**From:** Planning  
**Subject:** FW: CONSULTATION - APPLICATION 3/2020/0981, Land At Moran's Farm, Pendleton Road, Wiswell, BB7 9BZ

**From:** Parish Clerk <clerk@wiswellpc.org.uk>  
**Sent:** 16 December 2020 12:12  
**To:** Planning <planning@ribblevalley.gov.uk>  
**Subject:** CONSULTATION - APPLICATION 3/2020/0981, Land At Moran's Farm, Pendleton Road, Wiswell, BB7 9BZ

Scale(s) 1:200 @ A1 Date OCTOBER 2020
 Drawing no. ADM/20/34/01 Rev.

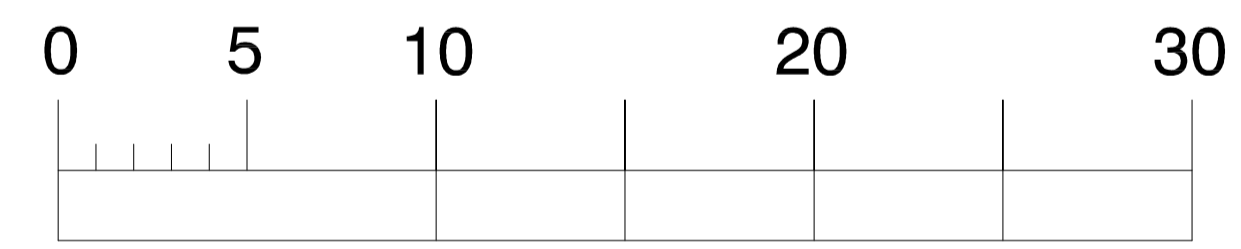
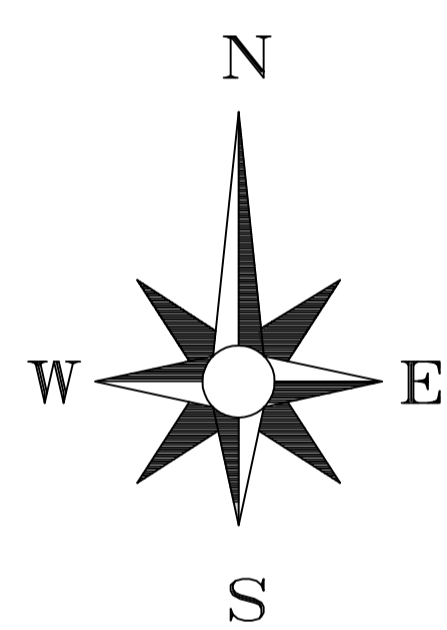
Noting the close proximity of the AONB and the number of trees being removed, the Parish Council ask that a landscaping and planting scheme be applied to limit the visibility of the development when viewed across the valley towards the elevated AONB behind the development.

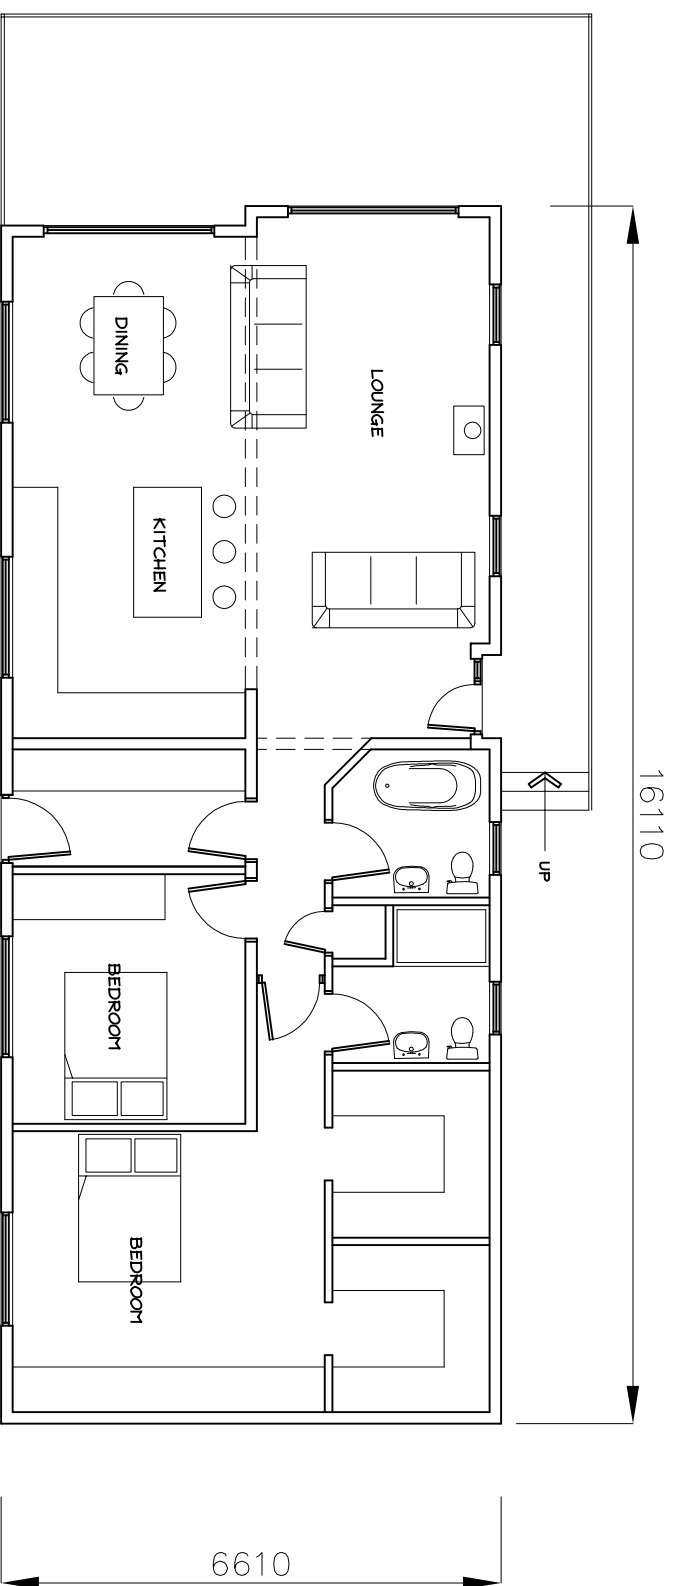
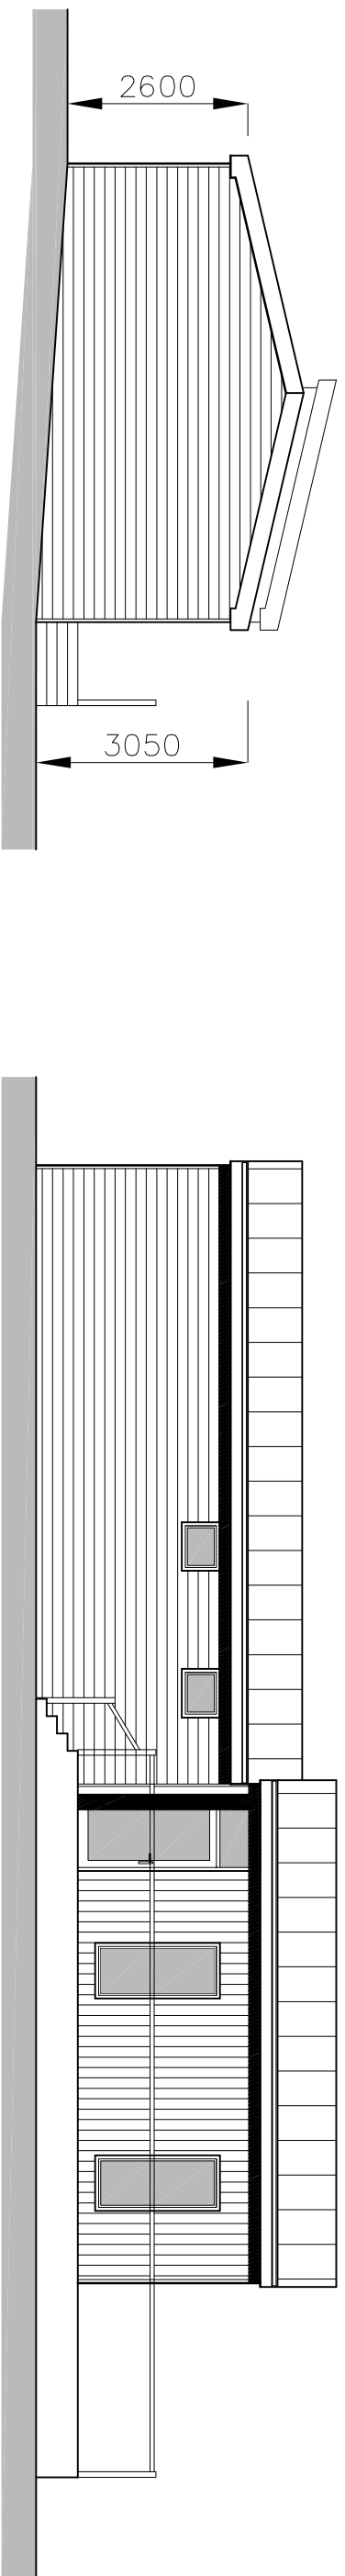
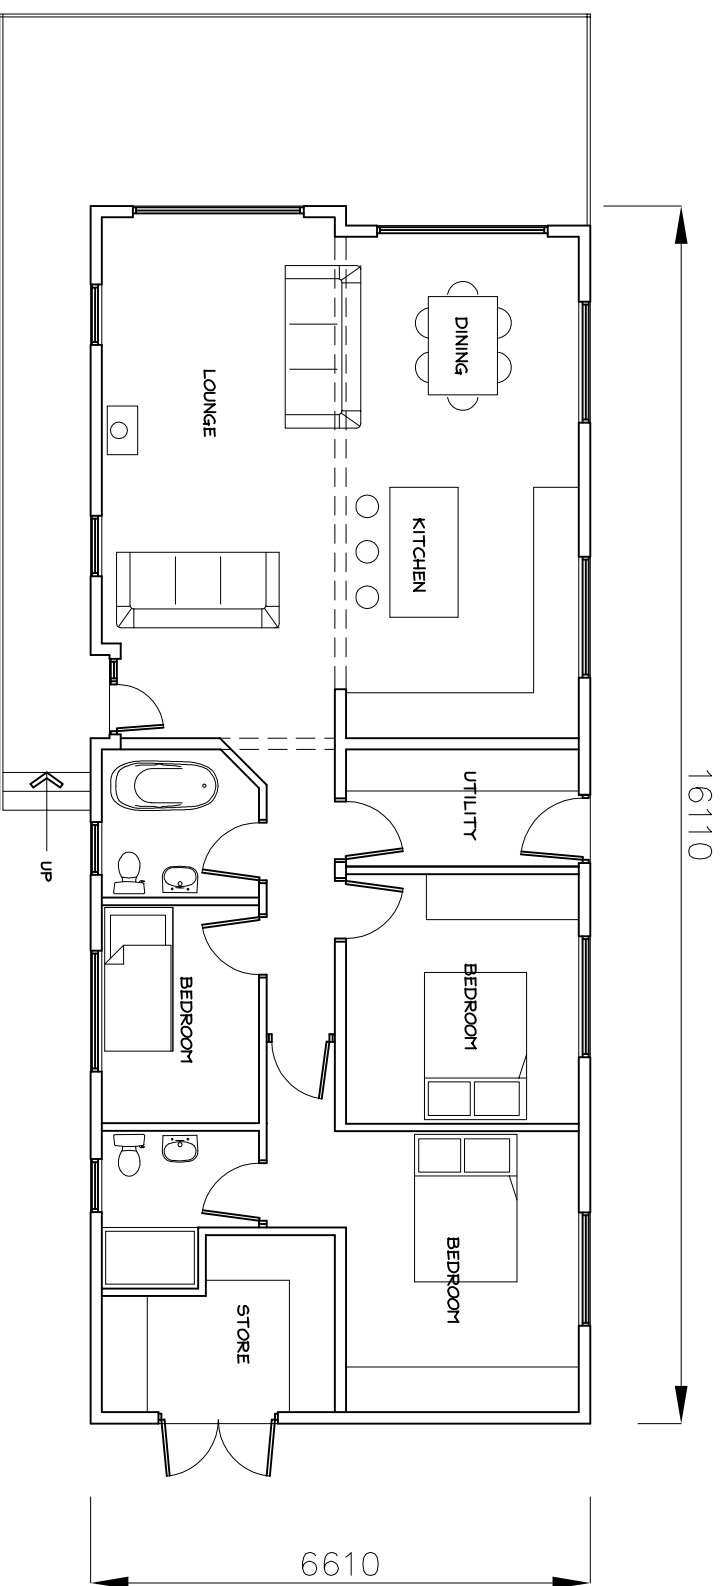
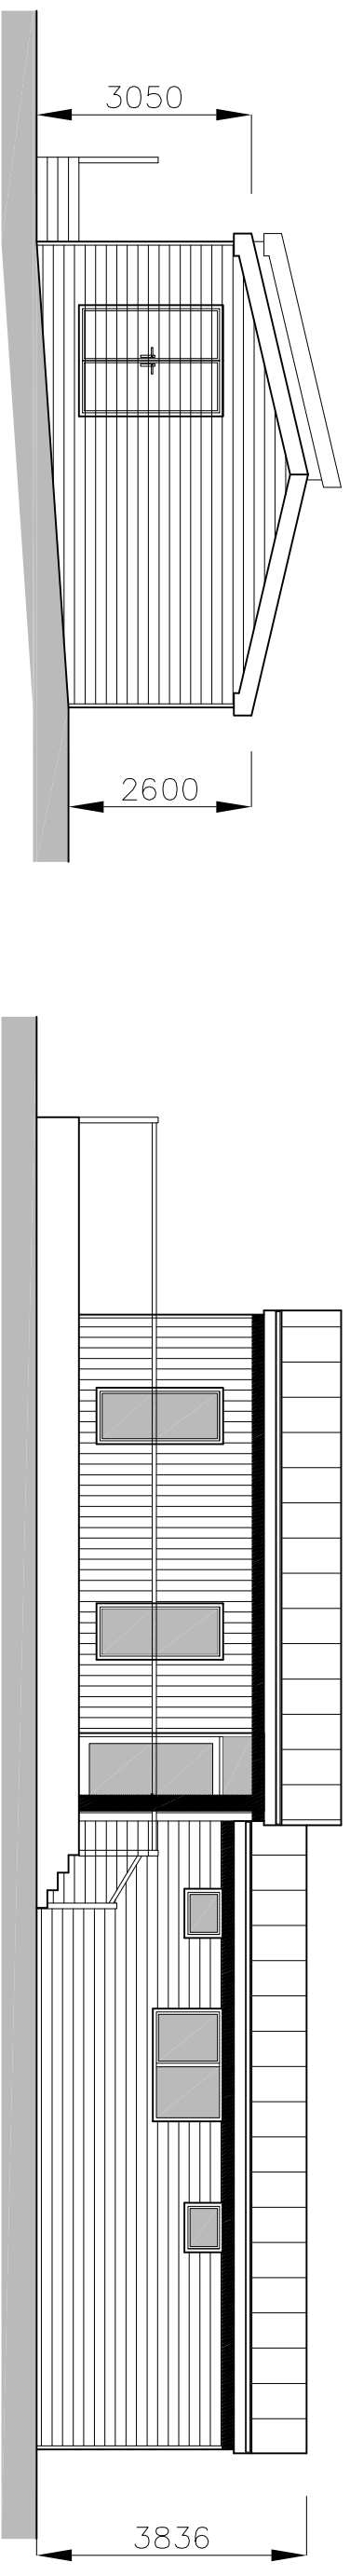
The Parish Council have no objection in principle to the four holiday lodges if they are semi-permanent structures/mobile type buildings. It is not clear from the plans submitted if this is the case, or are these lodges substantial masonry timber clad buildings?
